**Subject: MISC/259/2018/A - Mandalong Southern Extension Project - Mod 7**  
**LOT 54 DP 9632 LOTS 5/6 8 & 10 DP 262159 ML 1443 & 1543 SURFACE**  
**43.386Ha SUBSURFACE 3820.5Ha**  
**12 Kerry Anderson Drive, MANDALONG NSW 2264**

Council has reviewed Modification 7 to Development Consent SSD-5144 to include construction and associated works for a new 7.7km powerline corridor from Mandalong Road to the Mandalong Mine Access Site.

Figure 3 | Existing and Proposed 33 kV powerline alignment

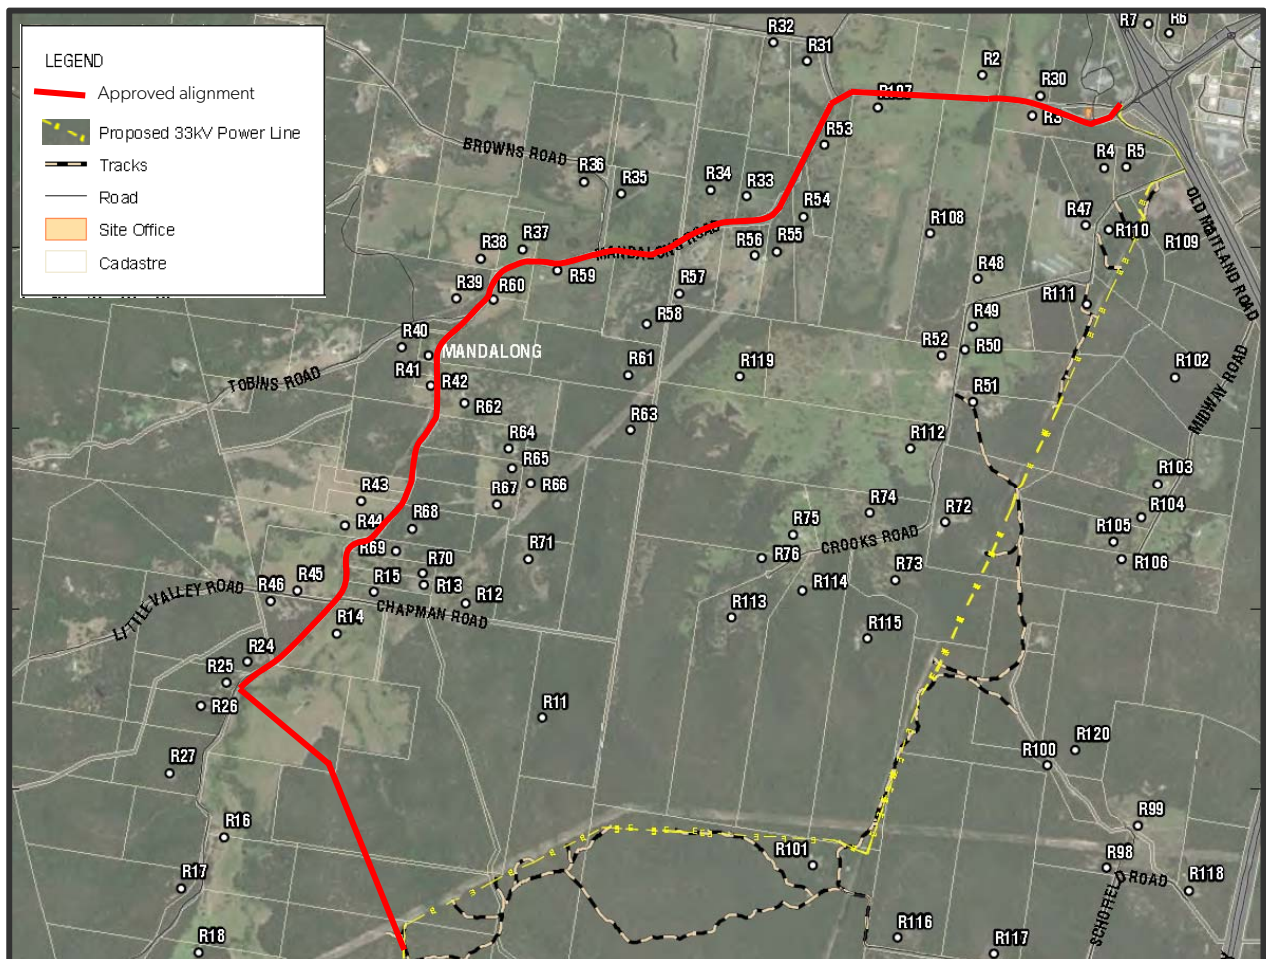
The proposal falls within land identified as flora and fauna corridor in Council's Native Vegetation and Corridor Map (2019). Accordingly, it is requested that an assessment be undertaken on post-construction corridor functionality (ie to demonstrate where and how fauna movement can occur along the proposed alignment post-development). Structures to facilitate fauna movement may be required.

Native vegetation is proposed for retention underneath the proposed transmission easement including span sections across valleys (Figure 9 and 10). It is requested that areas where clearing has been avoided are protected and secured via a legal mechanism, and on-ground fencing and signage is used to protect these areas from inadvertent clearing.

Clearing in the TL24 Offset Site is proposed. It is requested that the partial loss of this biodiversity offset site be offset within the Lake Macquarie Local Government Area, consistent with previous approvals relating to the TL24 Offset Site.

As a result of the vegetation clearing, it is anticipated that exposed soil will result in an erosion and sediment hazard. Council's Erosion and Sediment Control officer was not available to comment on this however on review of the Statement of Environmental Effects, this matter has only been addressed in a general way. Council requests that more specifically management detail is provided and appropriate conditions applied by the Department, particularly considering the soil landscape includes the Gorokan which has a high erosion hazard.
